Recommendation Report for Planning Permission for Works or Extension to a Dwelling

REF NO: A/143/25/HH

LOCATION: 80 Mill Road Avenue
Angmering
BN16 4HX

PROPOSAL: Roof extension to include 2x cottage dormers and 1x velux rooflight to the front elevation with a flat roof dormer window to the rear elevation.

80 MILL ROAD AVENUE, ANGMERING
Proposals 04
Aug 2025

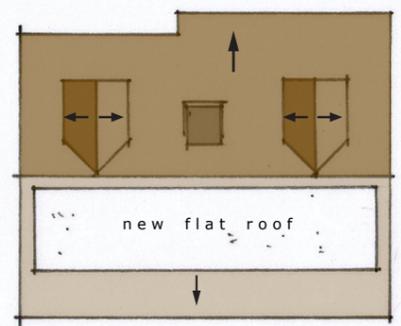
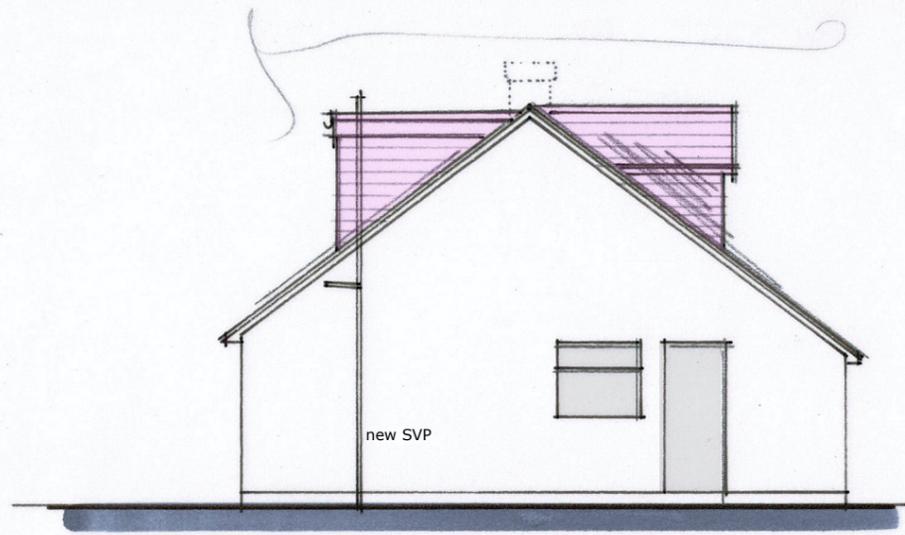
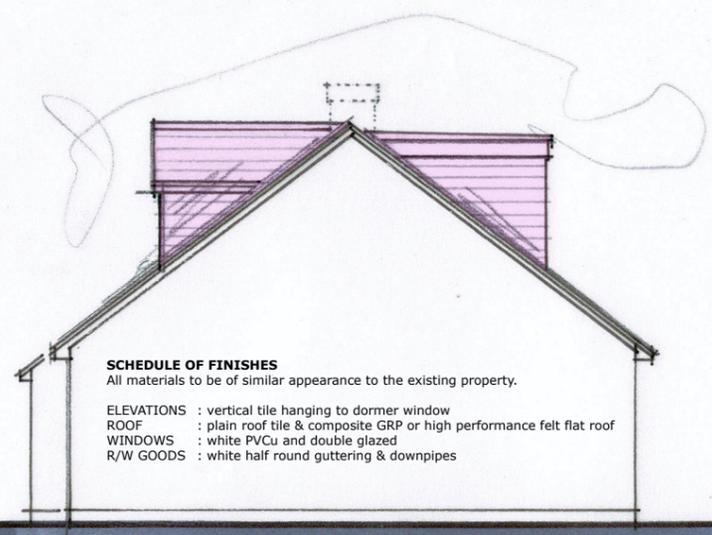
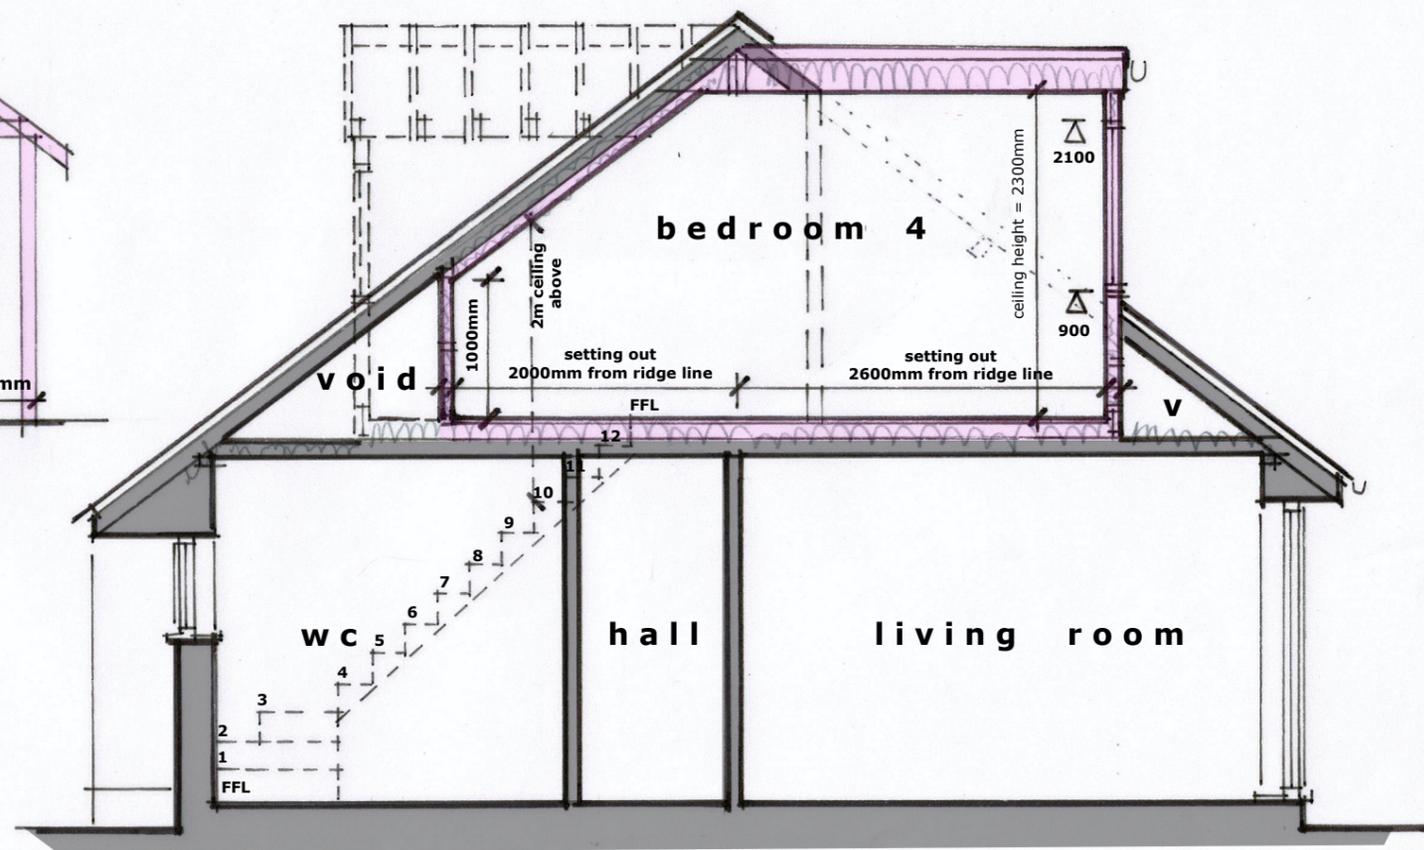
The 2 No. front dormers would have pitched roofs and would each measure 1.8m in width and 2.6m in depth. Part M of the Arun Design Guide requires front dormers to be centrally located and to not damage the original character and appearance of the building and its surrounding area, incorporating pitched roof in most cases. Part M also favours smaller scale dormers used in combination. There are examples of similar front dormers on the street scene as well as the immediate neighbour, No. 82 Mill Road Avenue. Therefore, the front dormers are acceptable as they would not appear out of keeping.

The proposed rear (south) dormer would measure 9.7m in width and 2.6m in depth. It would be set down 0.2m from the main ridge of the dwelling, and set in 0.5m from the flank elevations. The dormer is in partial conflict with the Arun Design Guide (ADG), which states that dormers should be minor incidents on the roof plane and incorporate pitched roofs in most cases, avoiding large box-shaped designs. The main roof ridge height of the dwelling would be retained, and the development would not project beyond the original footprint of the property which helps to minimise any visual harm upon the locality. Furthermore, a dormer of a similar size and scale could be constructed under permitted development. There are several examples of flat roof rear dormers along Mill Road Avenue, including No. 82. Therefore the proposed dormer would not appear out of character within the street scene.

1 No. rooflight is proposed to the front (north) elevation of the dwelling. The rooflight would be proportionate in scale and number, and would not result in any harm in this regard, furthermore there are several examples of front rooflights in the street scene.

The front dormers would be contained within the front roof slope, and would not result in any overbearing or overshadowing impacts. The front dormers would contain front facing windows which would provide views onto Mill Road Avenue and would not result in harmful overlooking effects.

The proposed rear dormer would be contained within the existing rear roof slope of the host dwelling, and would not result in overshadowing or overbearing impacts to neighbouring properties. Part M of the ADG states that private rear gardens should be at least 10.5m in depth to preserve neighbouring privacy. 3 No. windows are proposed within the rear elevation of the dormer which would have a separation distance of 10.5m to the rear boundary. Therefore, the rear dormer would comply with the guidance outlined within the ADG in this regard. Whilst it is noted that some views of neighbouring gardens would be available from the rear dormer, it is noted that a rear dormer could be constructed under permitted development, and as such, the proposed rear dormer would not result in unacceptable overlooking.
